Engineers Comments Regarding Surface Water Drainage

Application Reference:	Y/71/25/DOC	Reviewer Reference:	ADC/EXT4b
Planning Officer:	Simon Davis	Date of Review:	09/06/2026
Site Name:	Land at Stakers Farm North End Road Yapton		
Application Description:	Approval of details reserved by condition imposed under Y/44/17/OUT relating to condition 18-updated copy of management manual for SuDS system.		
Assessment Number:	2 of 2

Job Title LAND AT STAKERS FARM YAPTON		
Drawing Title SW MAINTENANCE PLAN (70 UNITS SCHEME)		
Client DANDARA LIMITED (SOUTHERN)		
Scale 1:500 @A1	Date JAN 26	Designed AK
Drawn AK	Checked BO	Approved BO
Job No 19-156	Drawing No YAP-130-090	Rev A

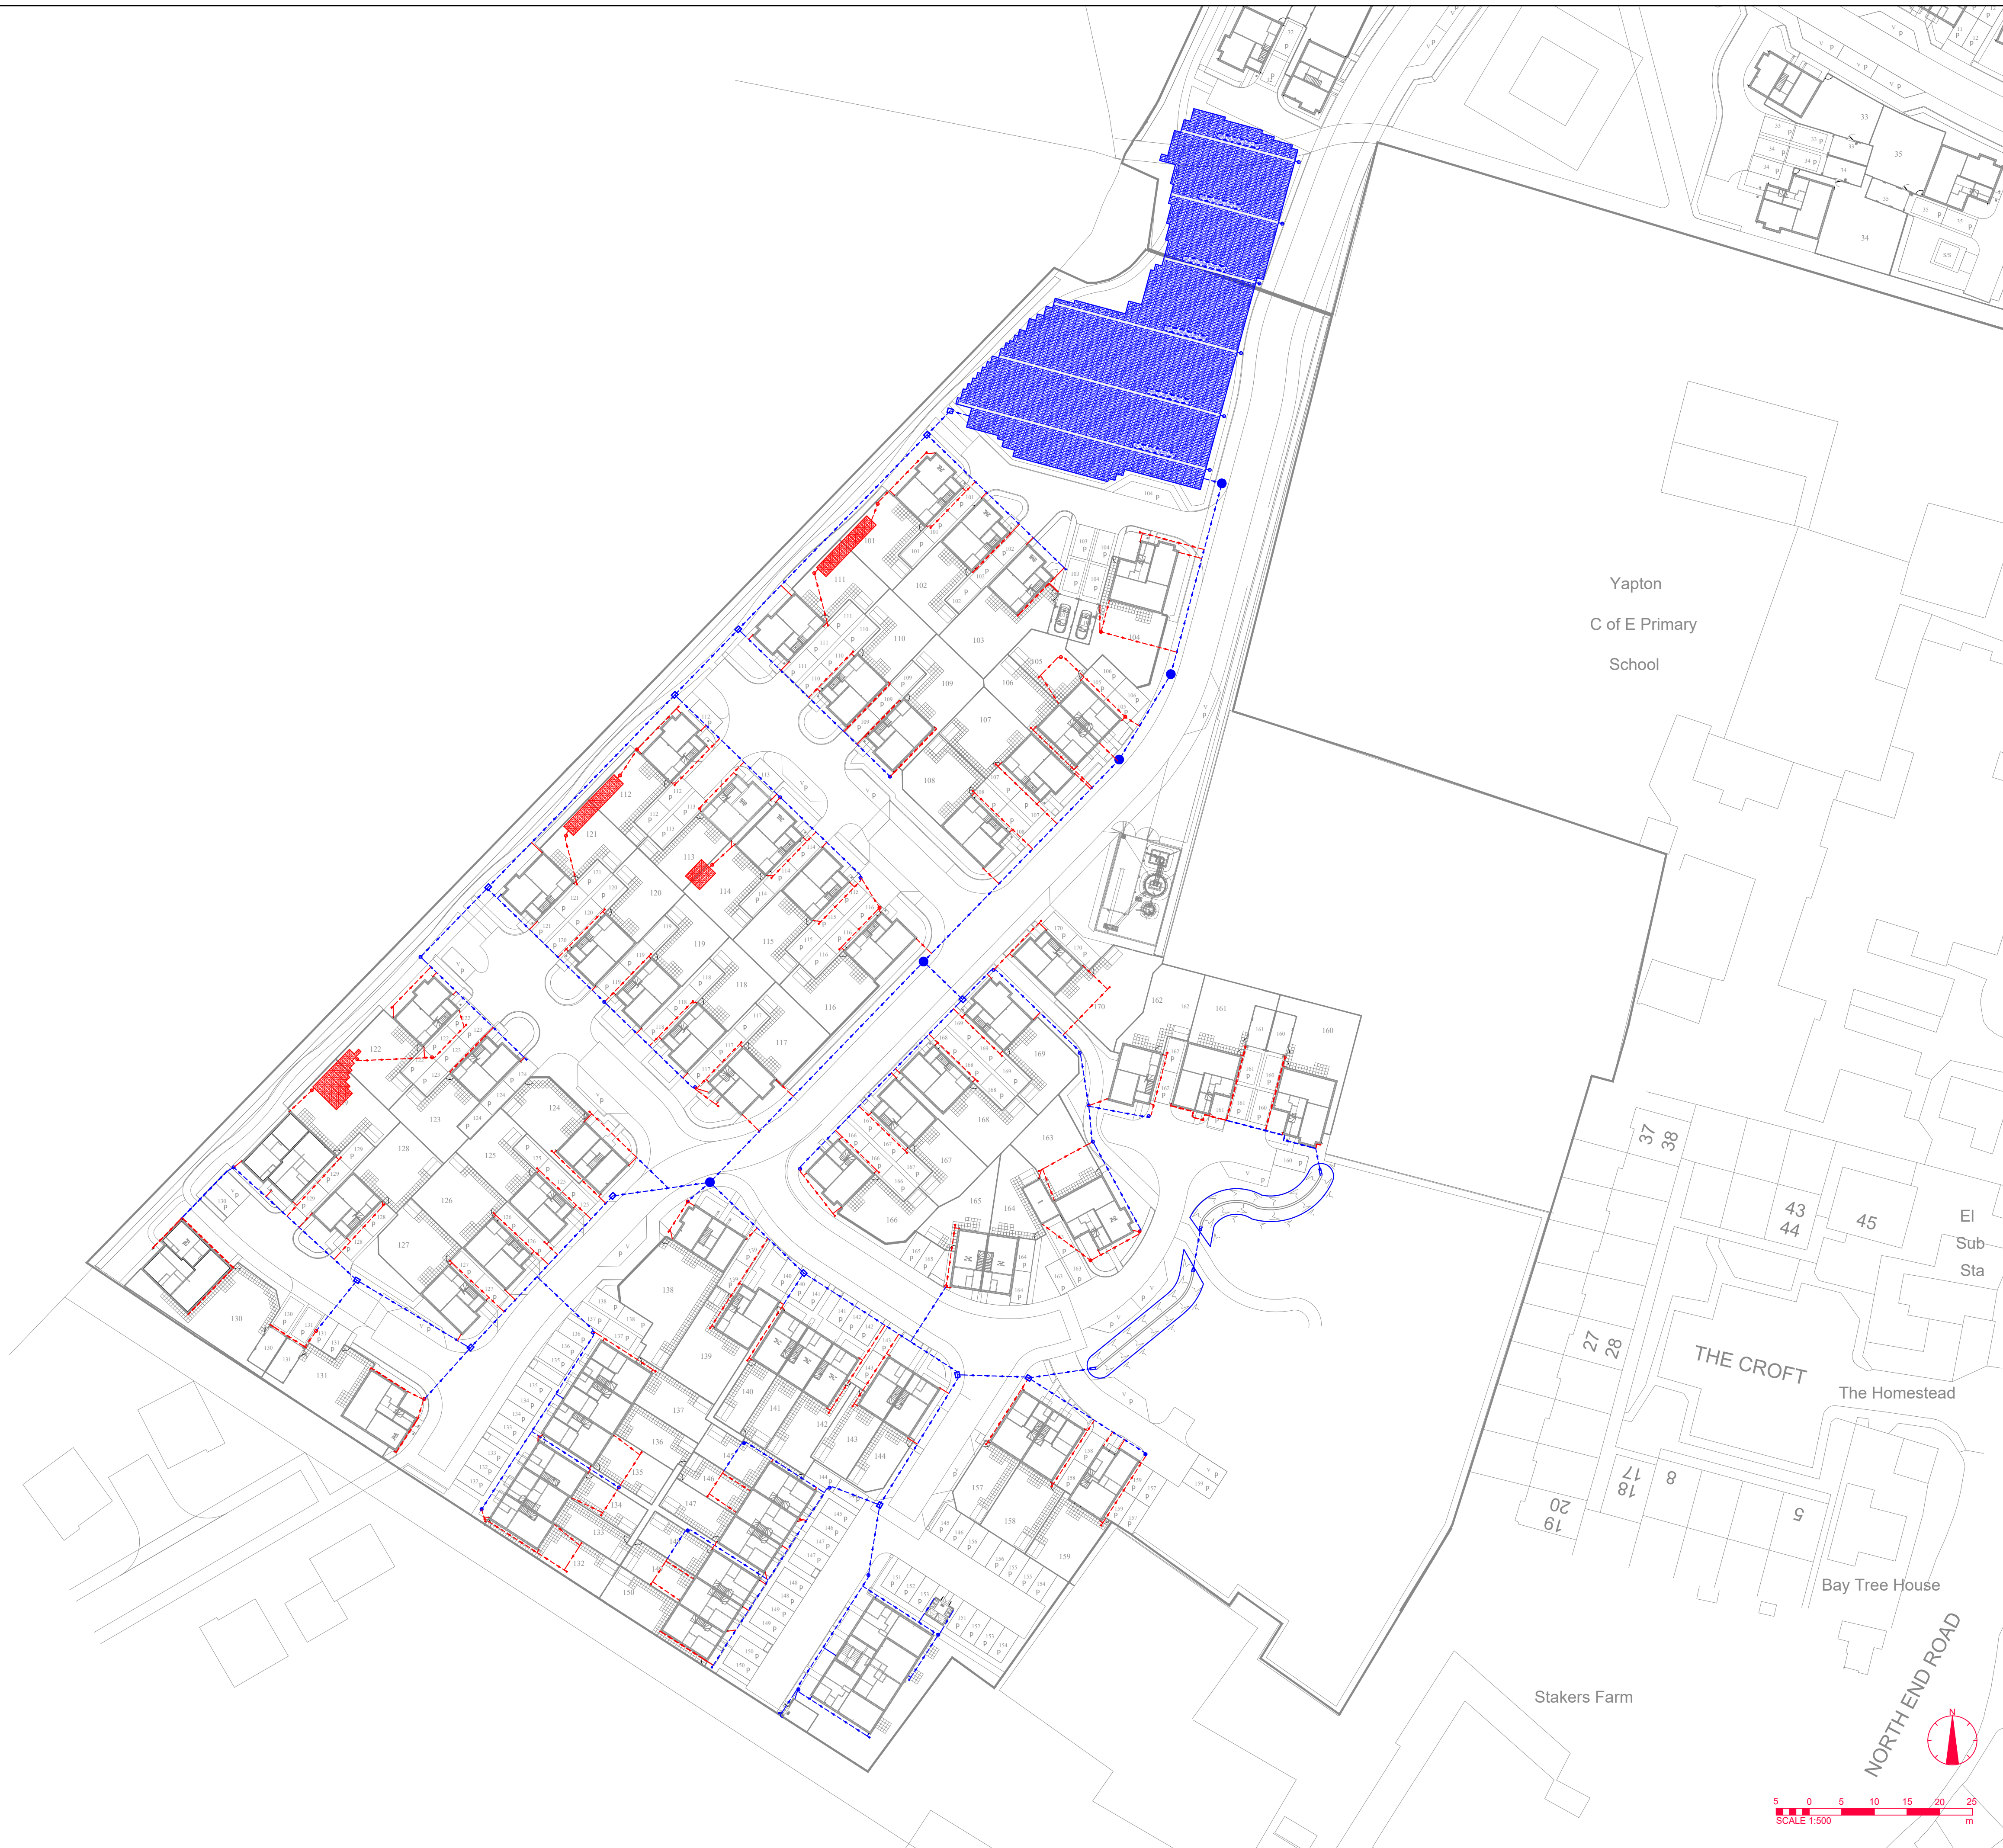
construction details need to be included		
3.	Please provide a plan showing maintenance responsibility should be included in the report	Additional drawing YAP-130-090 provided that differentiates the responsibility between management company and respective householders.	Thank you for providing this but please add a key to this drawing to identify which the red colour and blue colour drainage relates to please	Submitted but not appended. Item closed but administration to be resolved.
